Our Ref: AW/79/20/HH
Your Ref:

Town & Country Planning Act 1990 (as amended)
Town & Country Planning (Development Management Procedure) (England) Order 2015
Application for Planning Permission for Works or Extension to a Dwelling

Development Side extension to enlarge kitchen and dining room
Location 175 Nyetimber Lane Aldwick

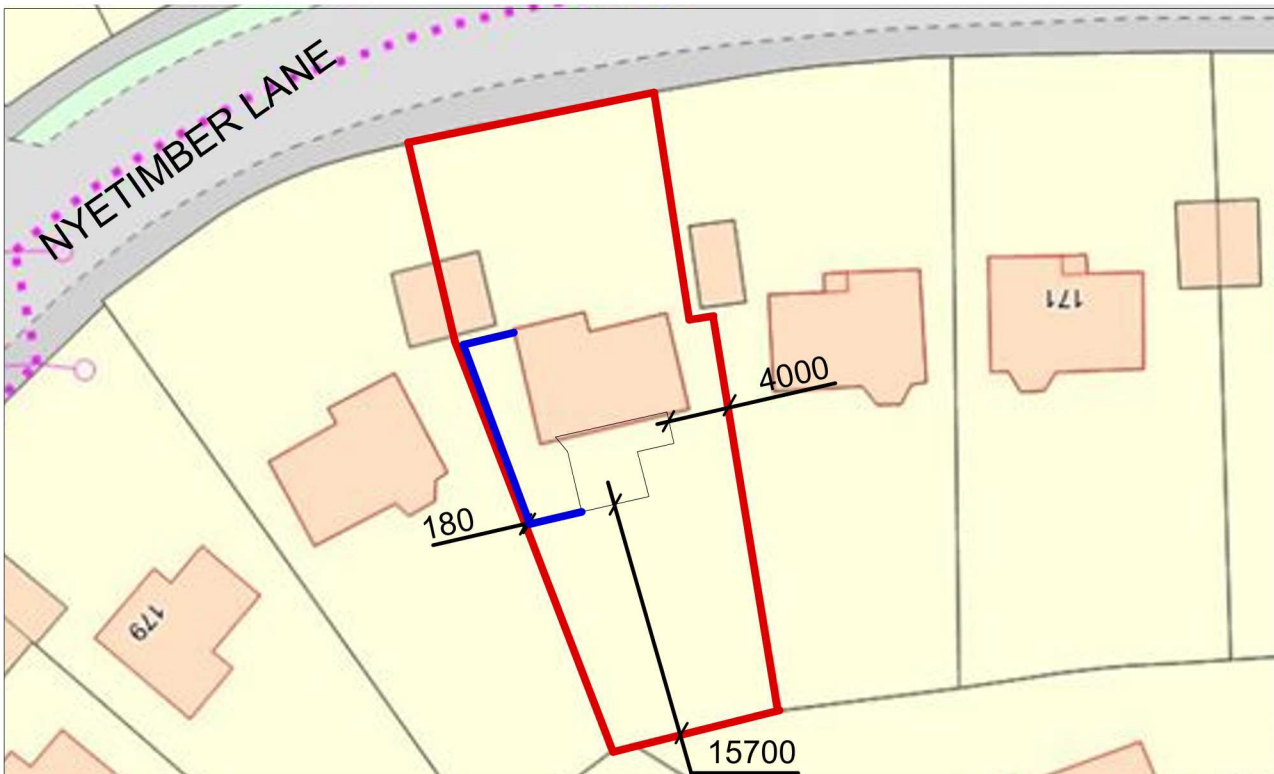
Block Plan

The size of the proposal does not match between the Block Plan and all other proposed plans.

The dimension 2800 and 14000 do not measure correctly.
